Application No: LU/300/14/HH

### Recommendation Report for Planning Permission for Works or Extension to a Dwelling

**LOCATION:** 46 Meadow Way  
Littlehampton

**PROPOSAL:** Front ramp and level entry. This application may be determined by Littlehampton Town Council under delegated powers.

Date: 5/SEP/2014 14/4167/3

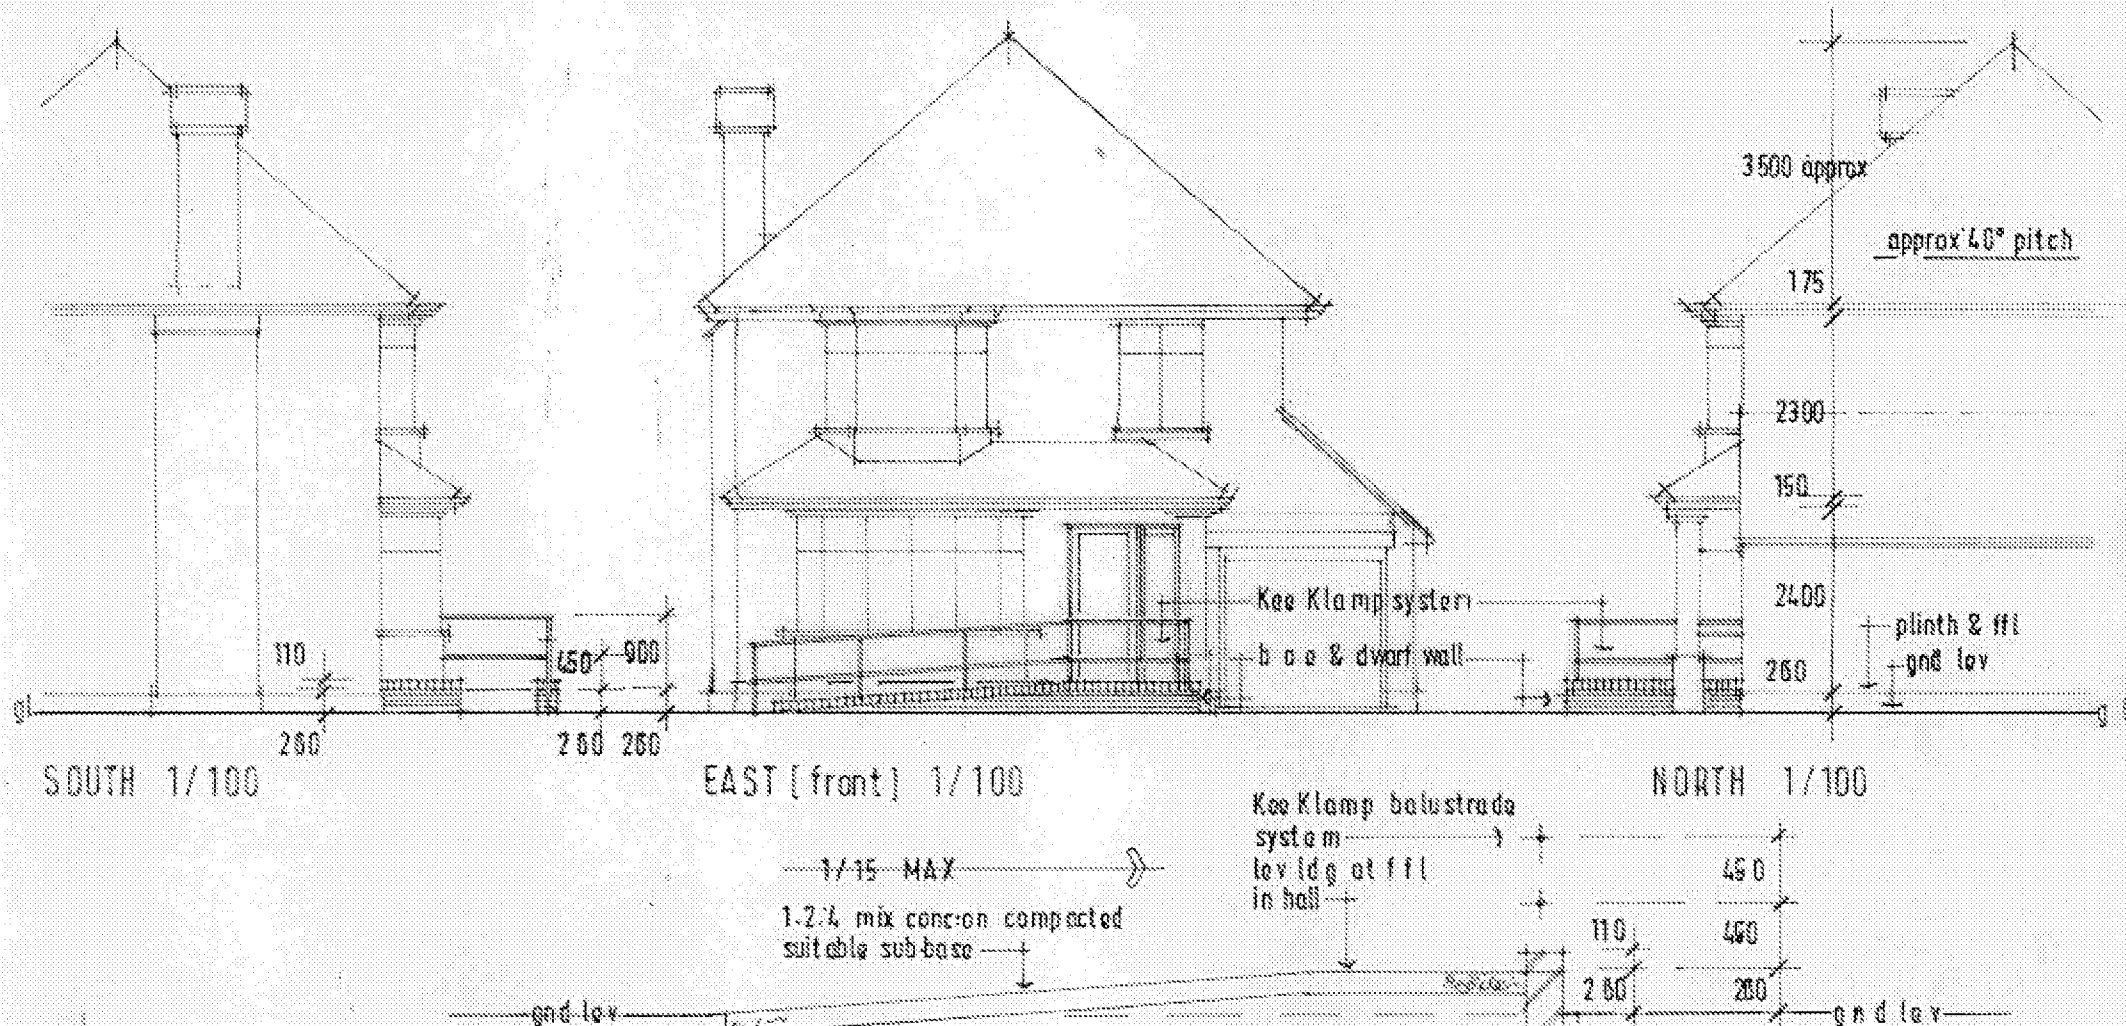
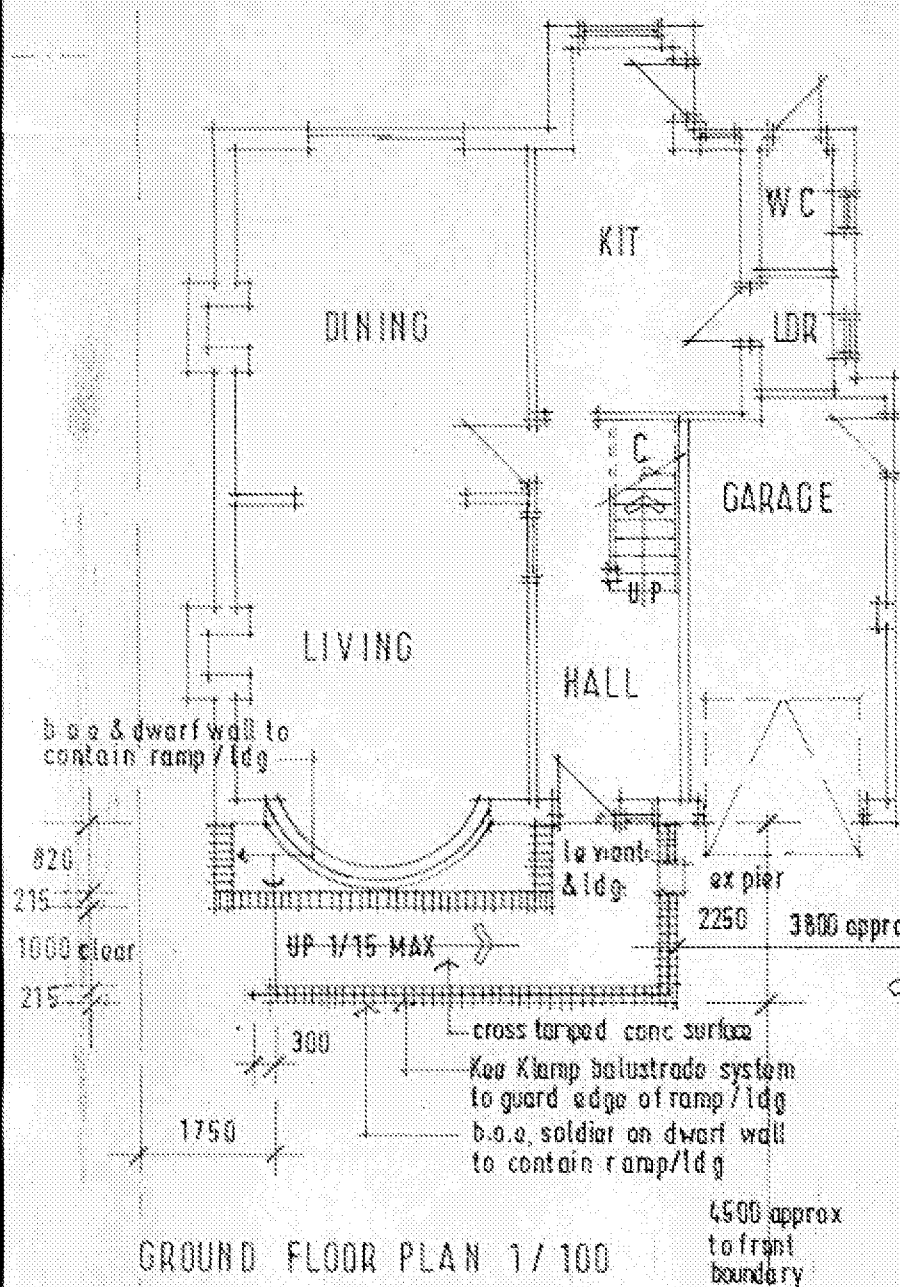
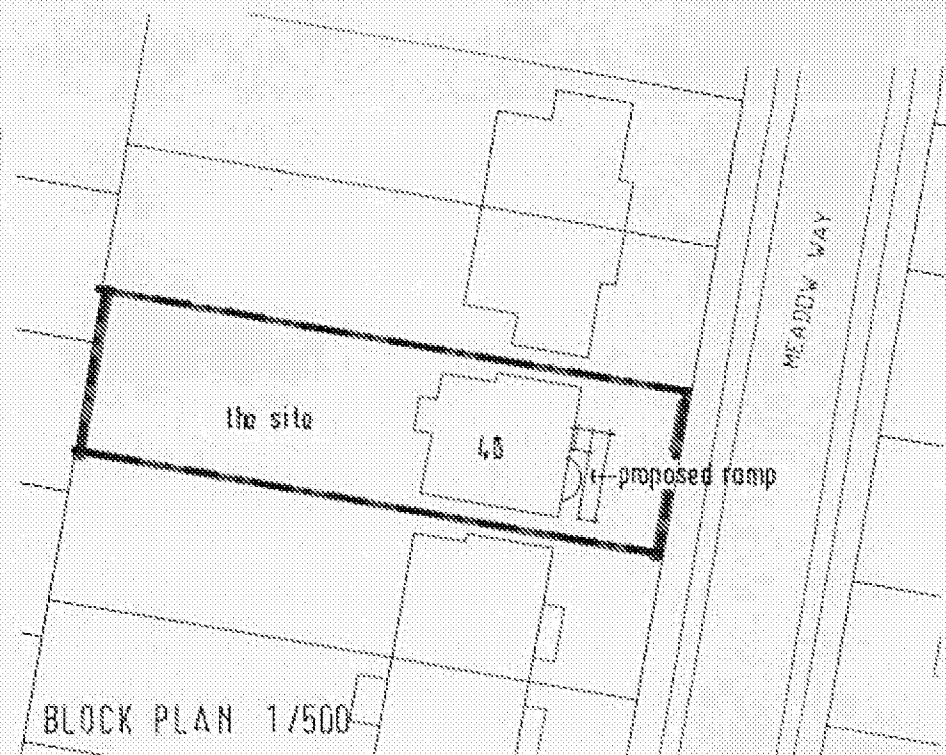
As above. The ramp measures approximately 5.9m in length, approximately 2.3m in depth and a ramp and railing combined height of approximately 1.2m. The ramp will be constructed from brickwork to match existing with metal railings.

The ramp will be at a maximum height of 0.4m with railings above. The railings and ramp will project forward of the property by approximately 2.3m. This is a comparatively small distance and the property is set comfortably back from the road by approximately 5m. Given the front boundary treatment comprising a brick wall at over 1.5m in height and with hedging to sides, it is considered that the structure will not be unduly prominent or obtrusive in the street scene. The brickwork plinth will also match that seen on the property so that it acceptably blends in.

The proposed railings form a visually lightweight and predominantly open structure and will be situated at acceptable distances away from neighbouring properties so as to not cause any overbearing or overshadowing effects. The ramp will offer an overall height increase of 0.4m above the existing ground level which given the side boundary treatment of hedging at over 1.5m in height and with only indirect views into public front gardens of neighbouring properties will not cause any unacceptable overlooking or loss of privacy either.

- 3 The materials and finishes of the brickwork used in the ramp hereby permitted shall match in colour and texture to that of the existing building.
